# KITTITAS COUNTY FIRE MARSHAL'S OFFICE

Re: Homestead View (BL-14-00009)

After conducting a review of the recent changes to the above named project, I have the following comments:

EXHIBIT  
 BOUNDARY LINE ADJUSTMENT  
 HOMESTEAD VIEW PLAT  
 LOTS C3 & C4

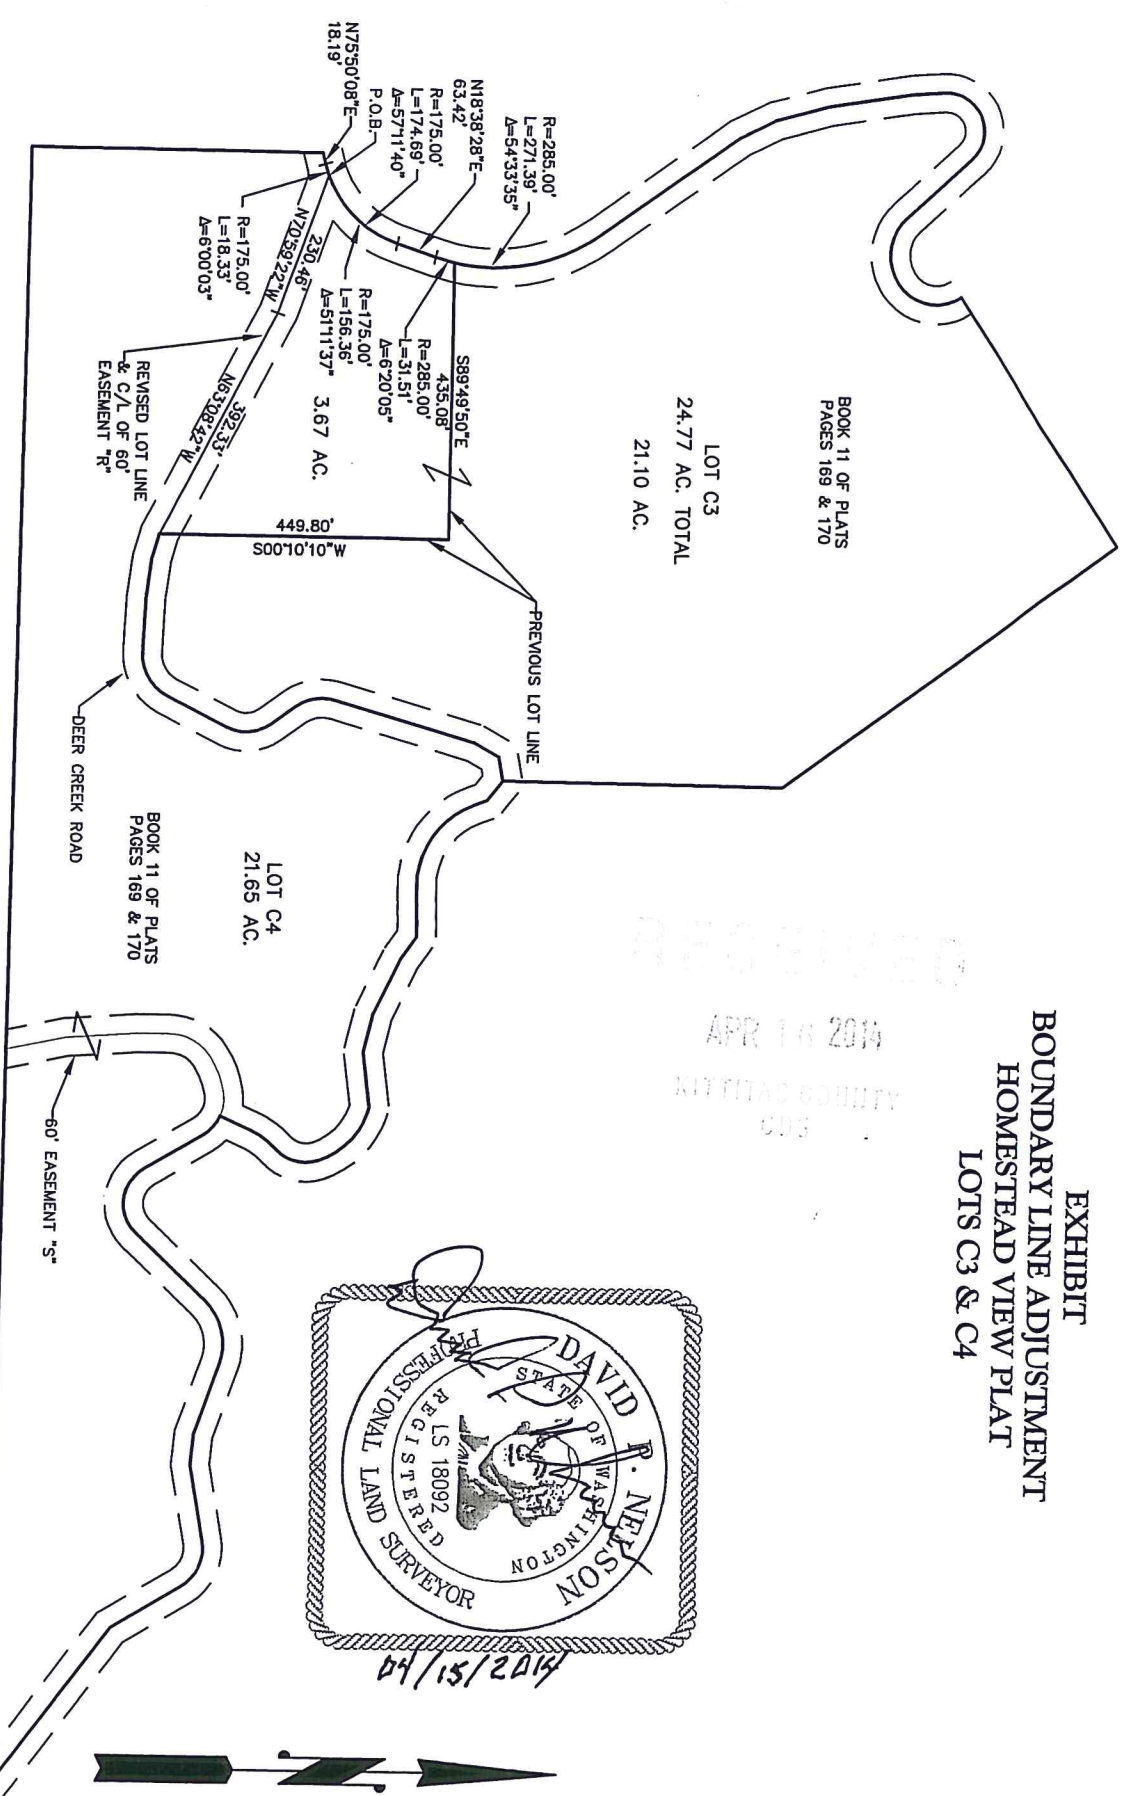
- Ensure that boundary line adjustments do not infringe upon existing structures, to include propane tanks, etc.
- Ensure adequate access for fire apparatus. Any driveways or access points created based off the new lot configurations shall comply with Kittitas County Code 20.02.030.
- All future development must comply with the International Fire Code.
